Subject: Great Western Battery Energy Storage System (SSD-12346552) Environmental Impact Statement (EIS)

Attachment A

Detailed advice to DPE Planning & Assessment regarding the Great Western Battery Energy Storage System (SSD-12346552)

Figure 2-3
Indicative Layout of the Site

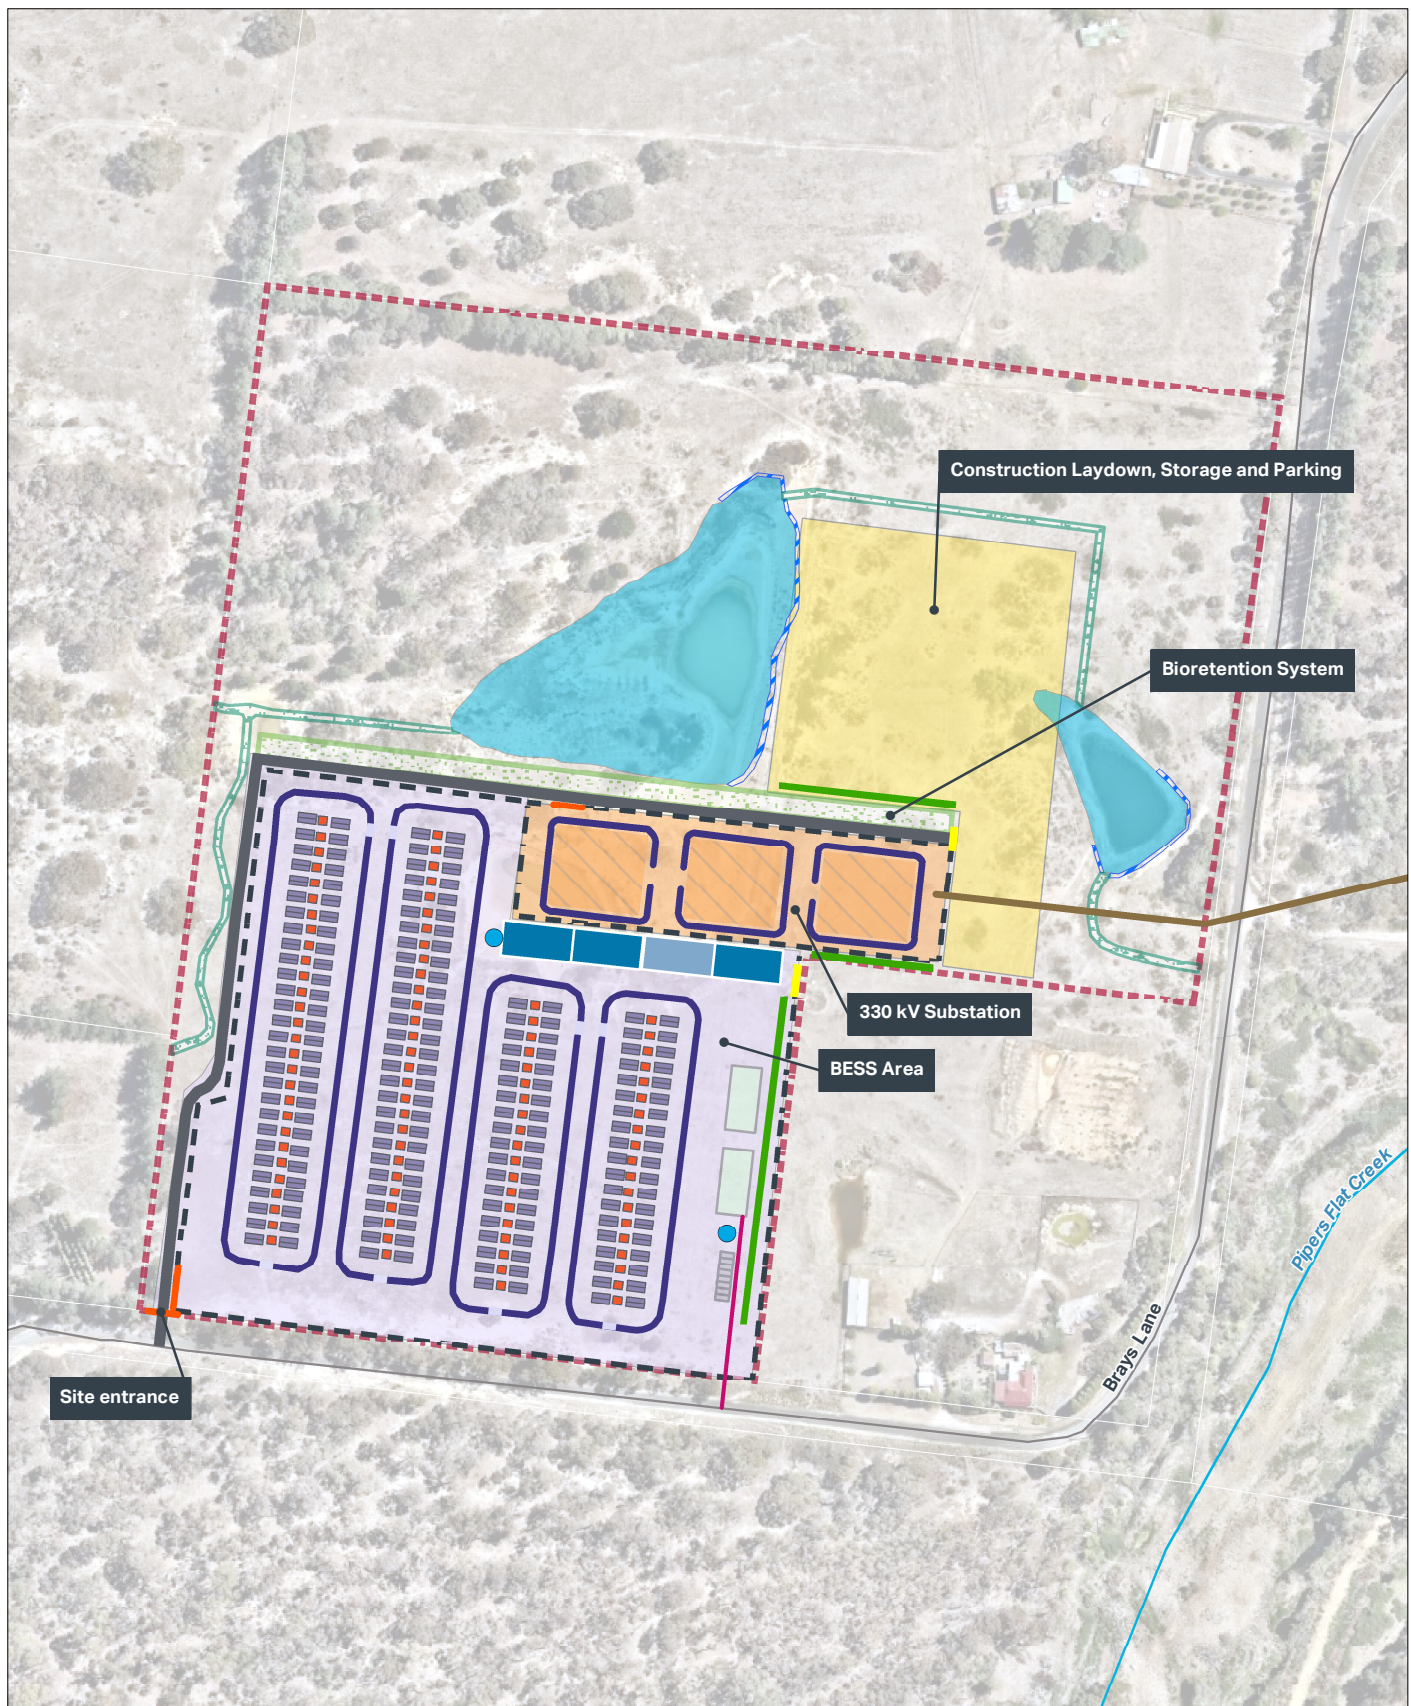
The flood modelling has indicated the proposed modified surface water system has significantly reduced the peak discharge from the site, and effectively reduced the runoff into the south eastern property's dams to zero. Further information is requested on the impacts to water availability downstream for both the environment and water users and also confirmation on the viability of the proposed options to provide alternate water supplies for the neighbour.

The proposed Dam 5 with a 32ML capacity will provide a number of functions including the capture of potentially dirty runoff from the project site, the capture of clean runoff from upstream and to mitigate potential downstream flow impacts by attenuating peak flows. Further clarification is requested as to how the proponent has considered this dam within the water regulatory framework and the best management practice of separating clean and dirty water. Relevant considerations for the water regulatory framework include the Maximum Harvestable Rights Dam Capacity, exclusions for dams under Schedule 1(3) of the *Water Management (General) Regulation 2018* and water licensing where an exclusion is not applicable.

- Clarify the potential impacts to downstream water users and the environment due to the proposed reduction in peak discharges and associated reduced water availability. Where alternate water supply options are proposed to water users confirmation should be provided of their viability
- Review the surface water management system at the site with the aim to maximise the separation of clean and dirty water at the site and to maintain water volumes for users and the environment downstream.

- Review the proposed dams at the site to ensure they meet the requirements of the water regulatory framework. This needs to include relevant exclusions and licence requirements.
